**Planning Application Ref:** BE/103/19/RES

**Location:** Land west of New Barn Lane, Bersted, PO21 5DN

**Description of works:** Approval of reserved matters following the grant of BE/77/16/OUT and BE/40/18/PL for 50no. residential units with associated roads, drainage & other related infrastructure

Mark Warwick  
Tree Officer / Parks and Greenspace Team

Copyright of ACD Environmental Ltd. All rights described in Chapter IV of the Copyright, Designs and Patents Act 1988 have been generally asserted: 2011. Copyright of this plan remains with ACD until all fees have been paid in full.

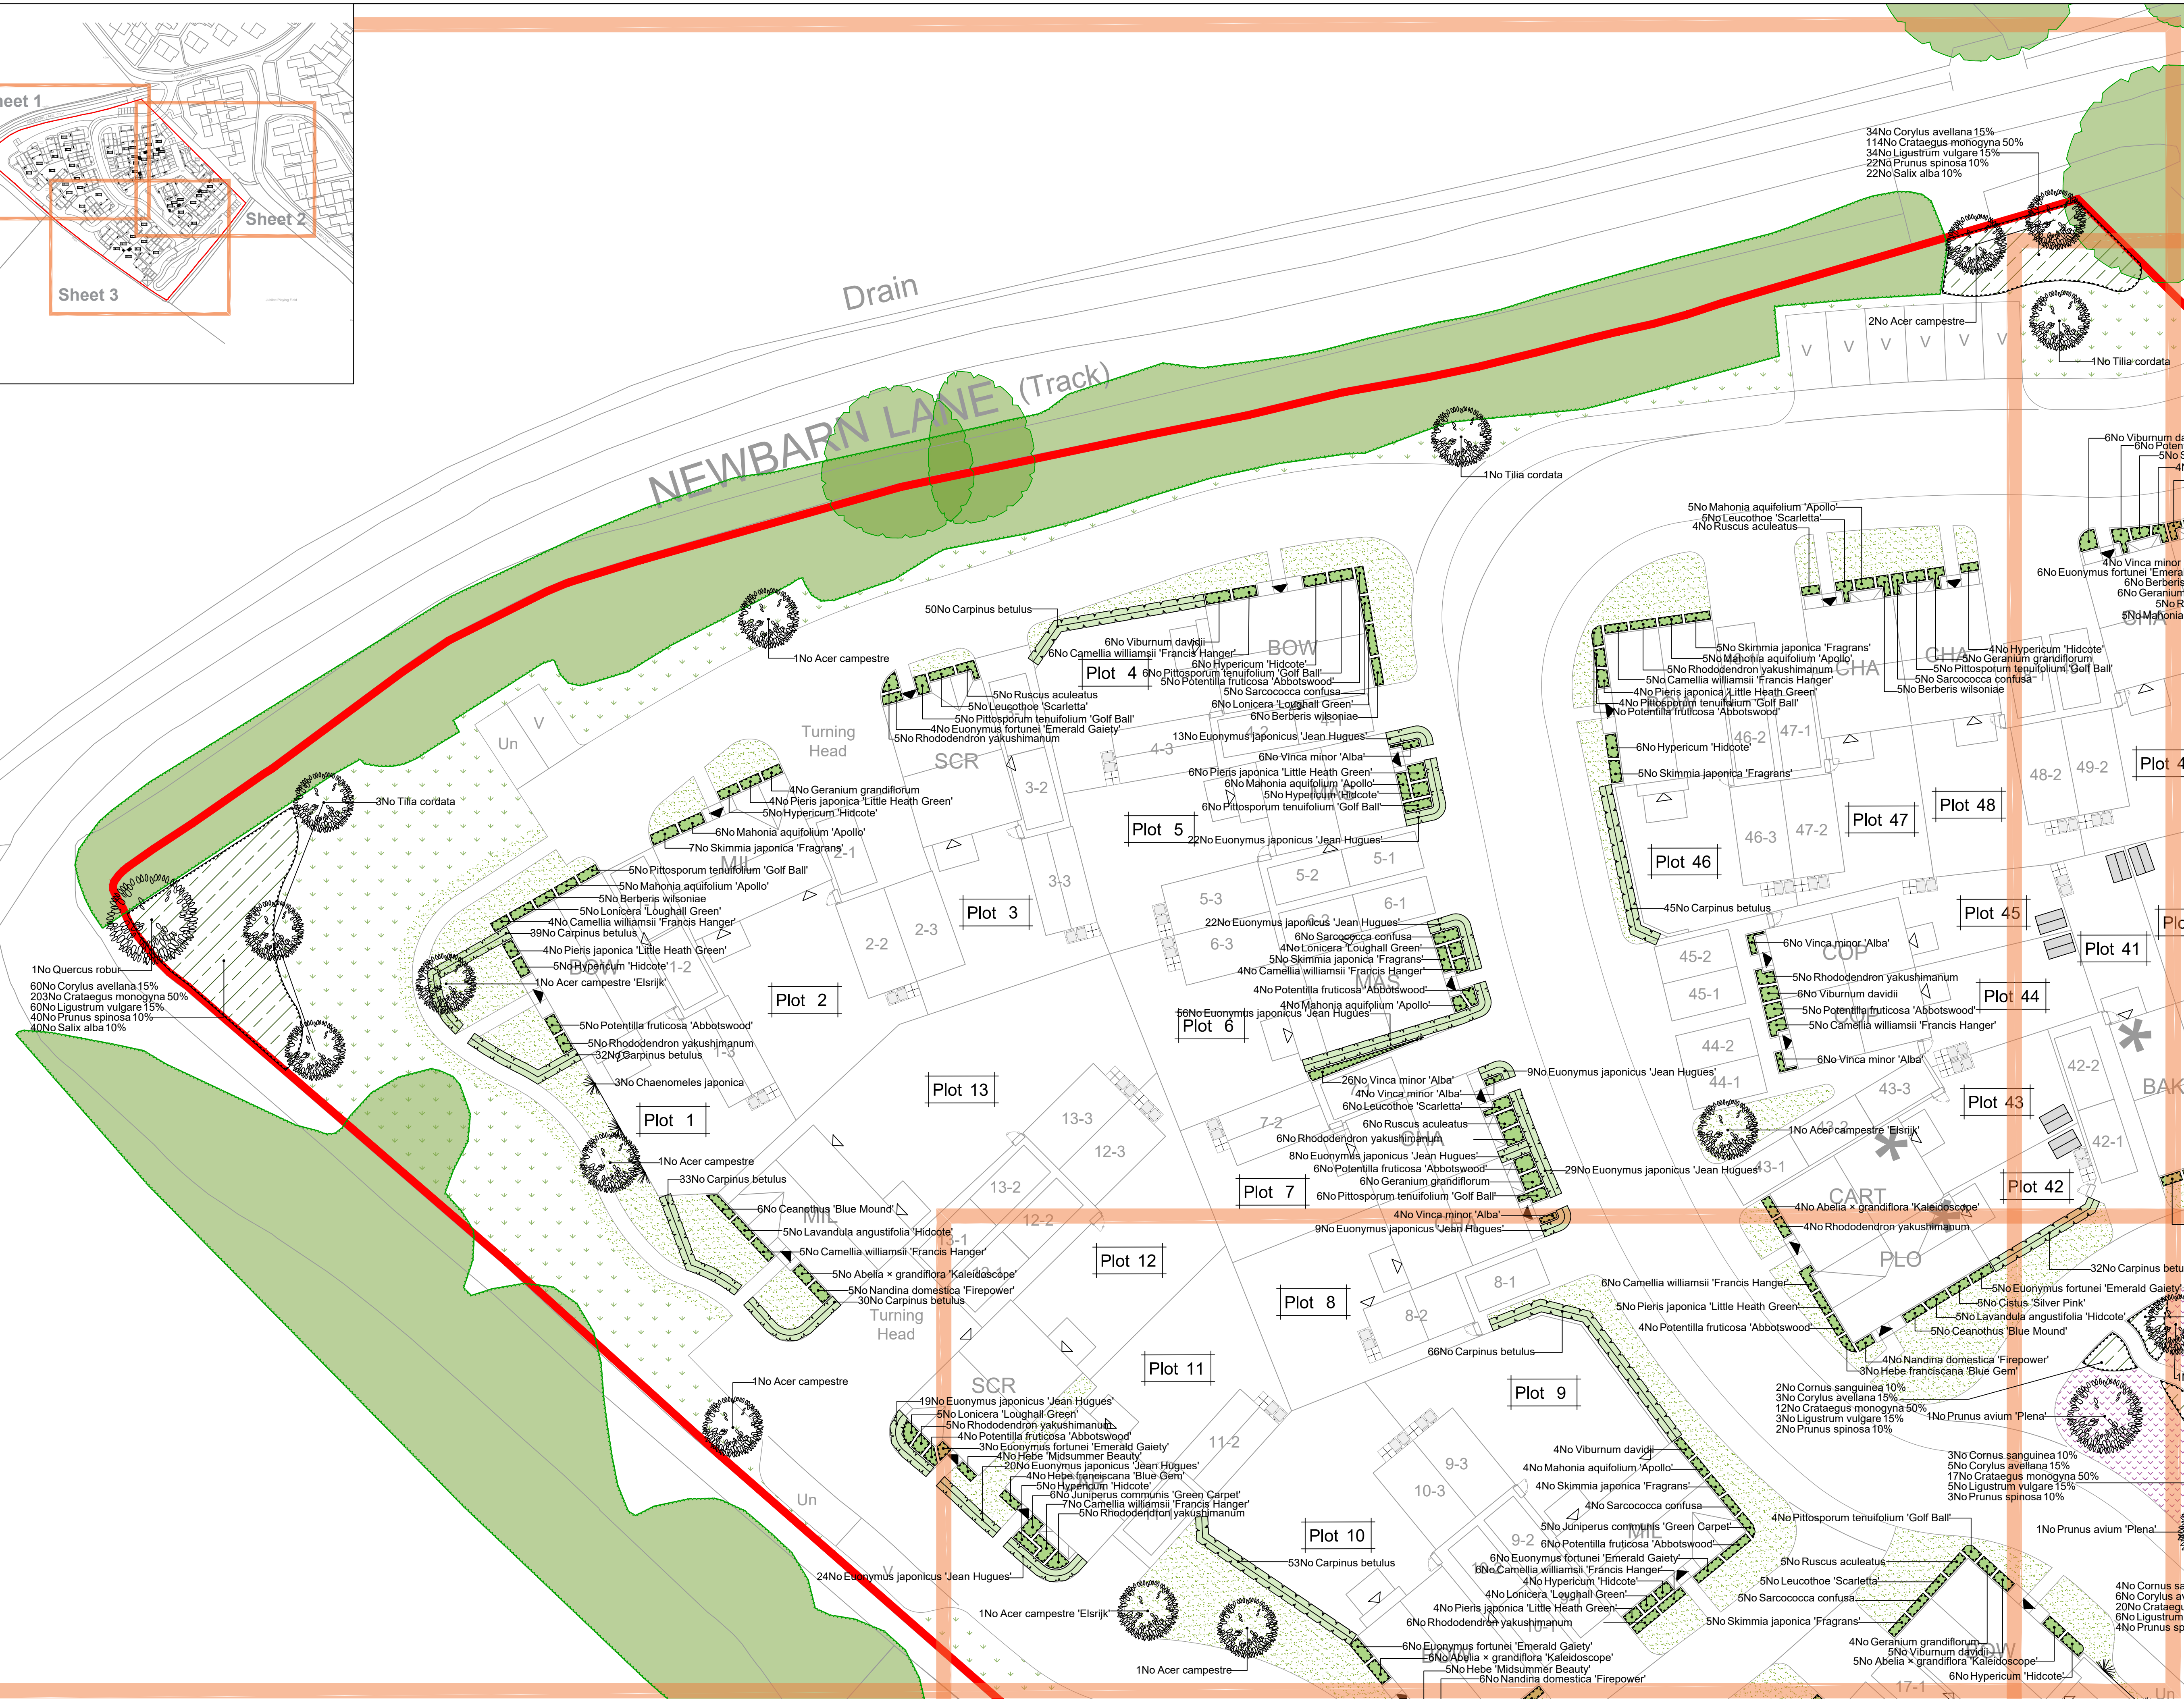
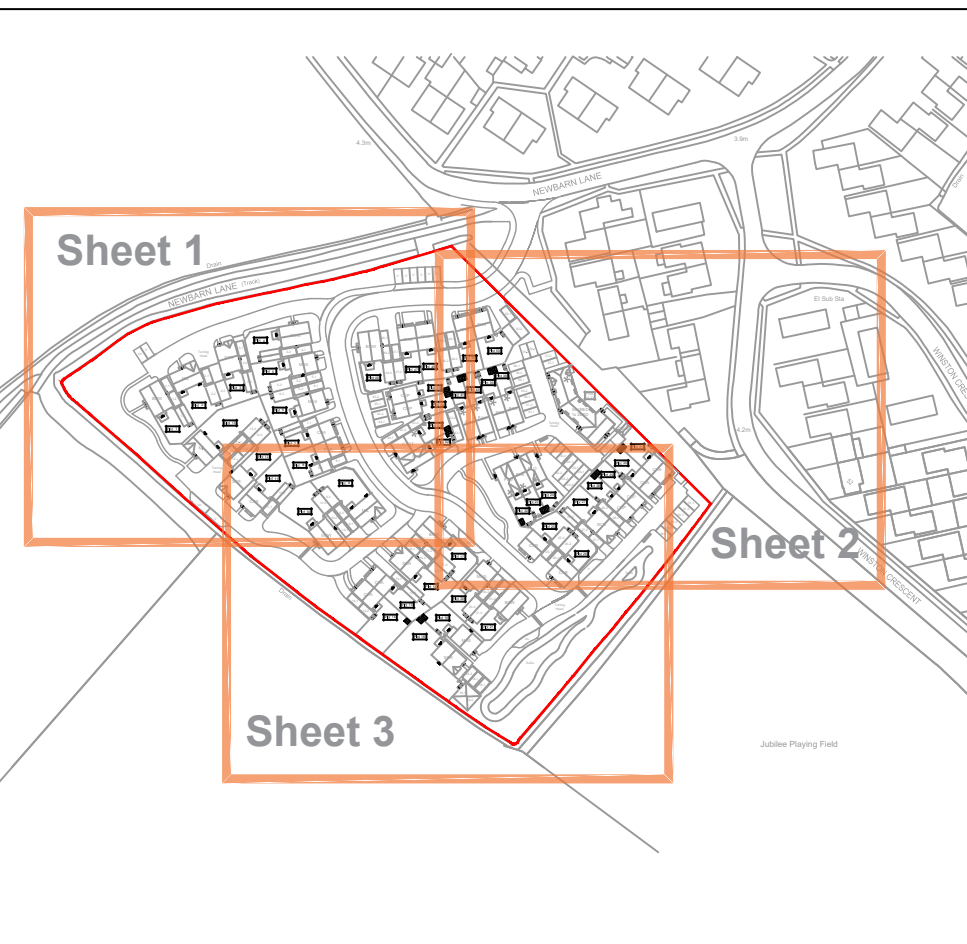
- The applicants have employed ACD Environmental to prepare an Arboricultural Impact Assessment & Method Statement along with a Tree Protection Plan for this project.

- The Tree Survey data is comprehensive and accords with the requirements of BS5837:2012. I agree with the retention category ratings for on and off-site trees.

- There are mostly off-site trees to consider, the site being an open field bordered by trees and hedgerow on all sides. The dominant trees are crack willow of mature age class in condition varying from healthy and vigorous to early decline and partial collapse. All trees around the site appear to have been given adequate room by this layout so as to fully respect and preserve their nominal root protection areas, although some facilitation crown pruning will be necessary to achieve satisfactory clearance. None of that is problematic or unduly harmful to the character of the area.

- Consideration must also be given to nominal root protection areas, anticipated future growth (root and branch) and high-water demand of these willow (*Salix fragilis*), when considering the location of any new drainage features/infrastructure and the necessary easement around the same, as well as any buffer zones (see drainage engineers recommendations).
